**SEAS DEADLINE 6 RESPONSE to APPLICANTS's SUBMISSIONS**  
**SINCE DEADLINE 5, ISH3, Action Points and ExQ3**  
**LANDSCAPE & VISUAL and CULTURAL HERITAGE**

**PINS Ref:** EN020026  
**DEADLINE 6:** APRIL 13, 2026

**RE: SEAS Response to Applicant's Submissions since Deadline 5, ISH3, Action Points and ExQ3 – Landscape & Visual and Cultural Heritage**

# EN020026 SEA LINK DCO – DL6: RESPONSE BY NICHOLAS BRIDGES

Figure 7. Sea Link 2023-10 PEIR Volume 3 Part 2 Chapter 2 Figures A, page 9:
 REPRESENTATIVE VIEWPOINT LOCATIONS AND SCREENED ZONE OF THEORETICAL VISIBILITY - PROPOSED SAXMUNDHAM CONVERTER STATION AND SPR FRISTON SUBSTATION (OPTION 2)

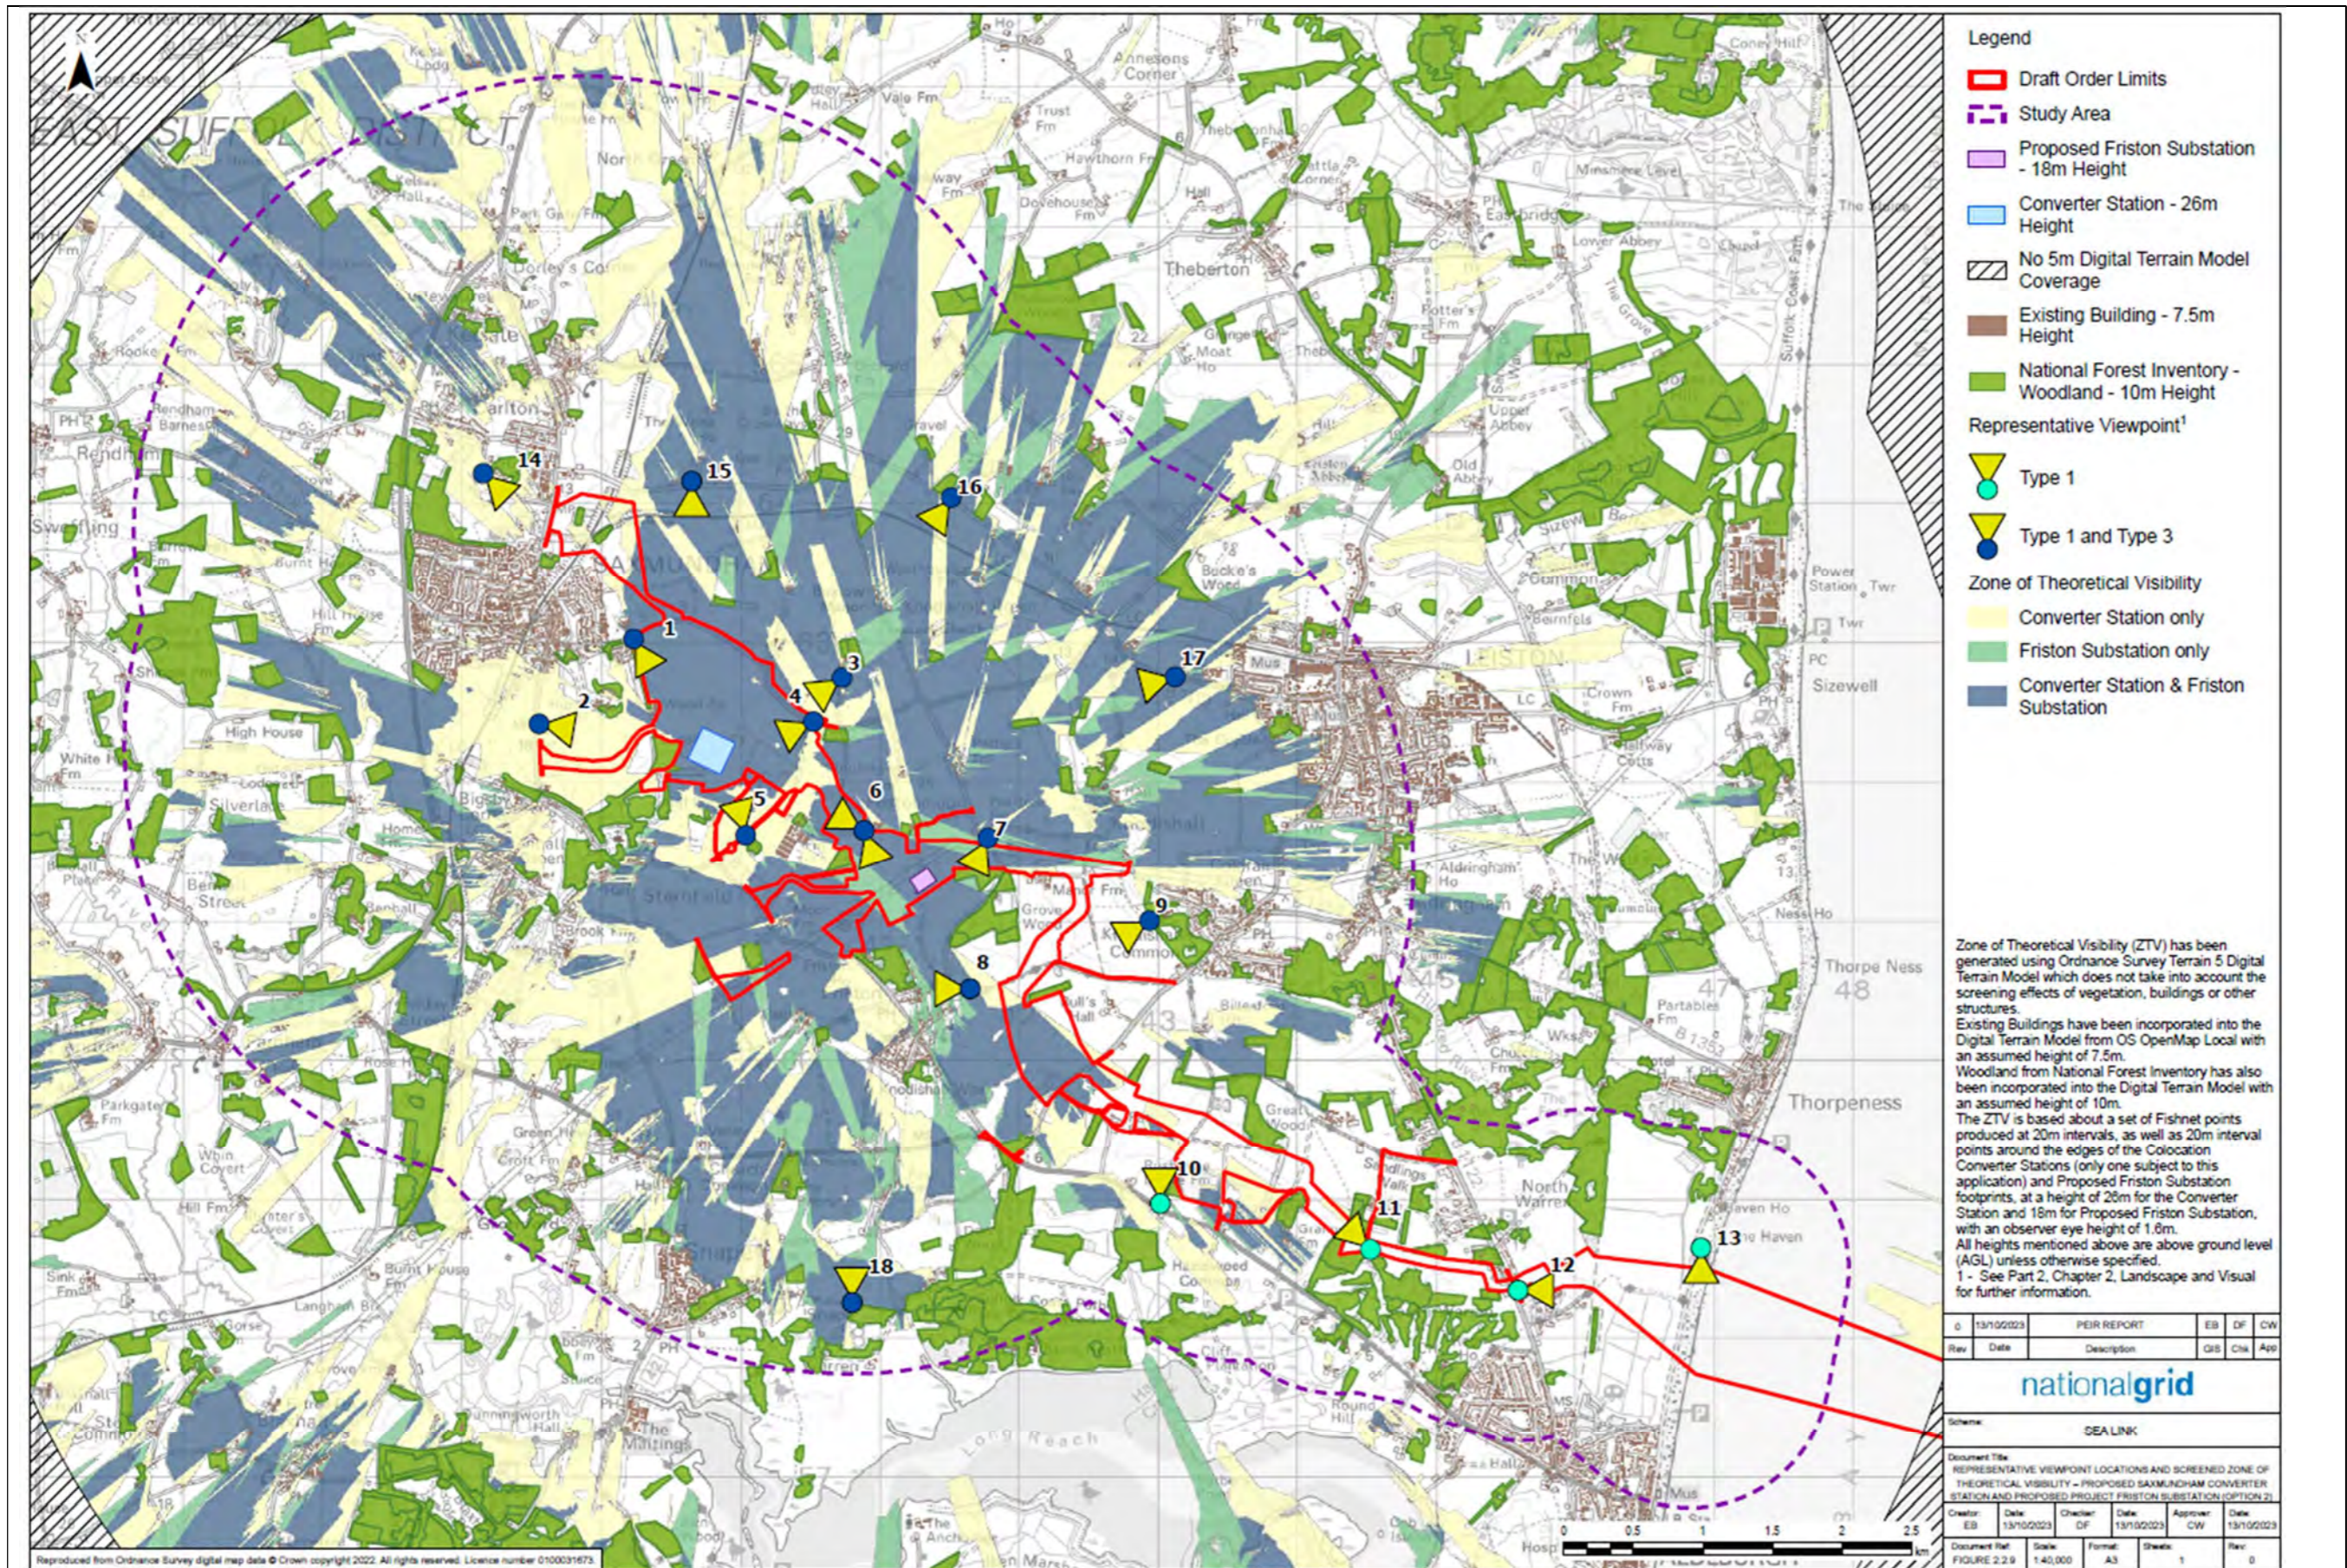
2.9. The ZTVs of the two Friston projects and Sea Link's PEIR have a similar pattern of visibility around their projects (see **Figures 1 to 11** below). Sea Link includes the National Grid substation at Friston which each of EA1N and EA2 also included. All Projects were modelled using OS contours, woodland and buildings at a generic height. Observer heights were a little higher for EA1N and EA2. The two Friston substations used the same parameter model as Sea Link.

2.11. The **first question** is: why are the PEIR and DCO plans so completely different? Were the heights in the model changed? Were the shadowing criteria altered? Which is correct? If the DCO is correct, were the EA1N and EA2 ZTVs incorrect? These are simple technical points which can be explained easily.

Figure 10. Sea Link 2023-10 PEIR Volume 3 Part 2 Chapter 4 Figures A Heritage & Landscape with ZTV, page 24 [Drawing 4 of 6]
DESIGNATED ASSETS WITHIN THE 2KM STUDY AREA ALONG WITH THE ZTV FOR CO-LOCATION AND FRISTON

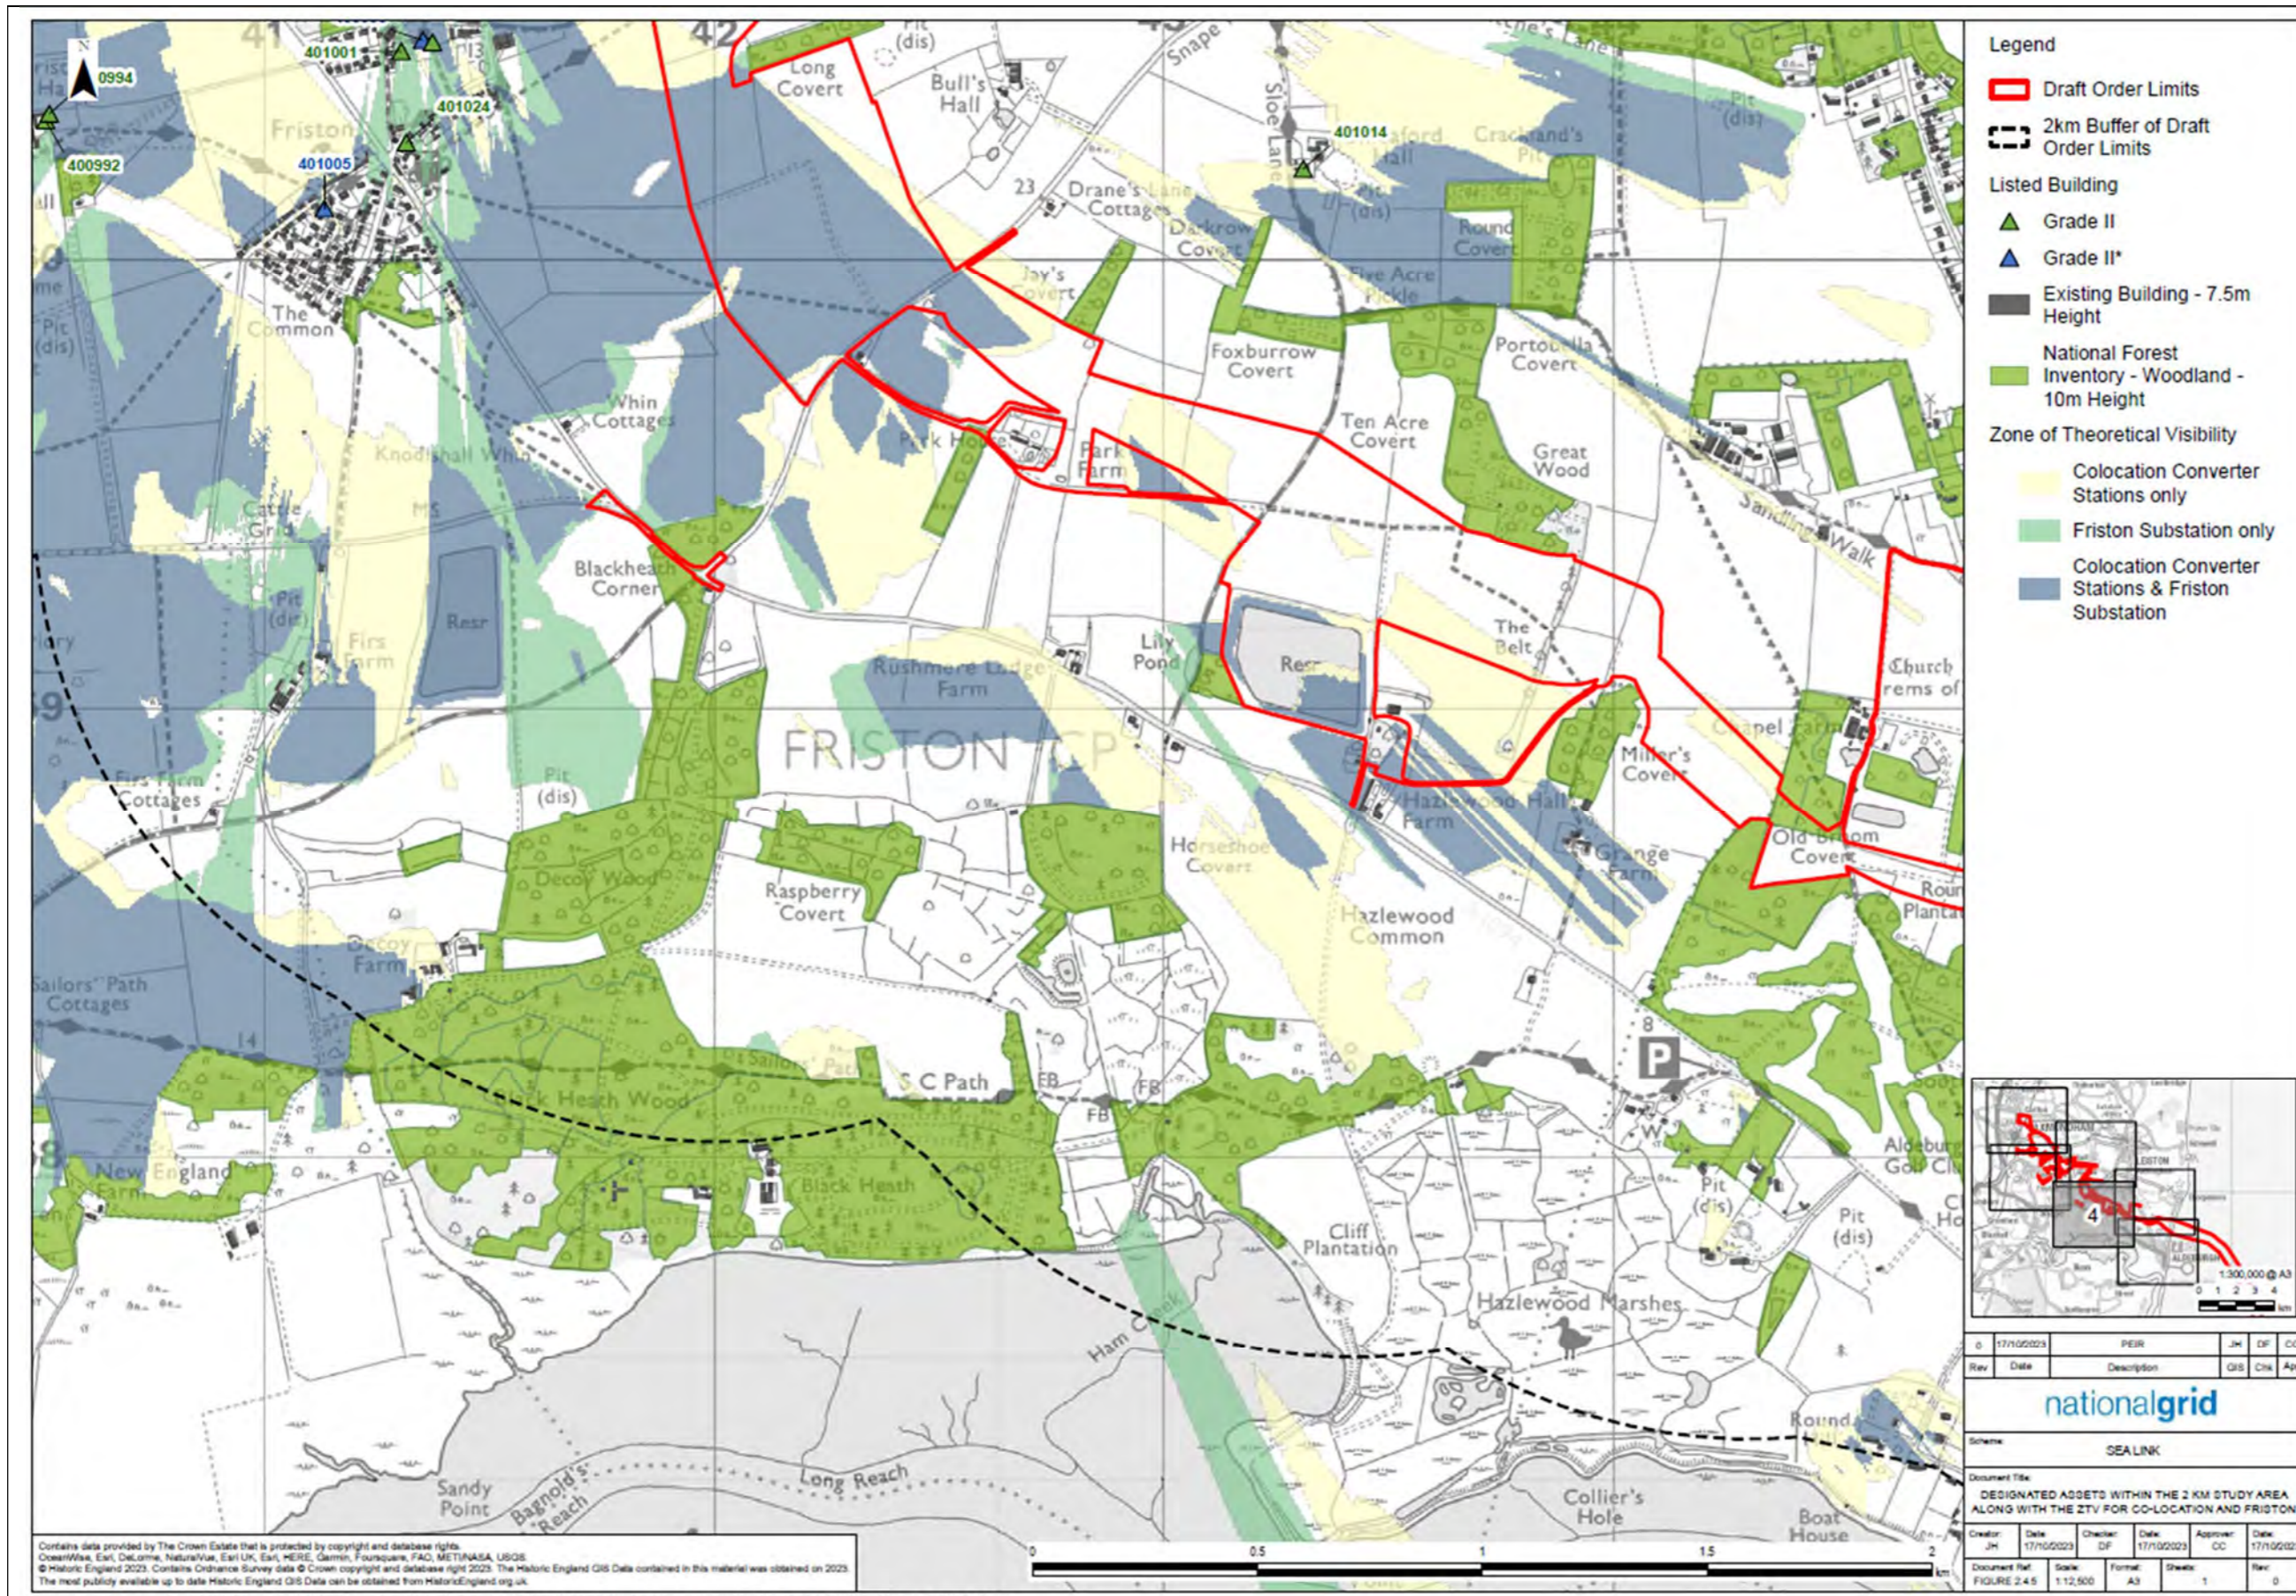
2.19. The Sea Link ES LVIA decided not to extend the coverage of its ZTVs when its PEIR had already revealed visibility of the
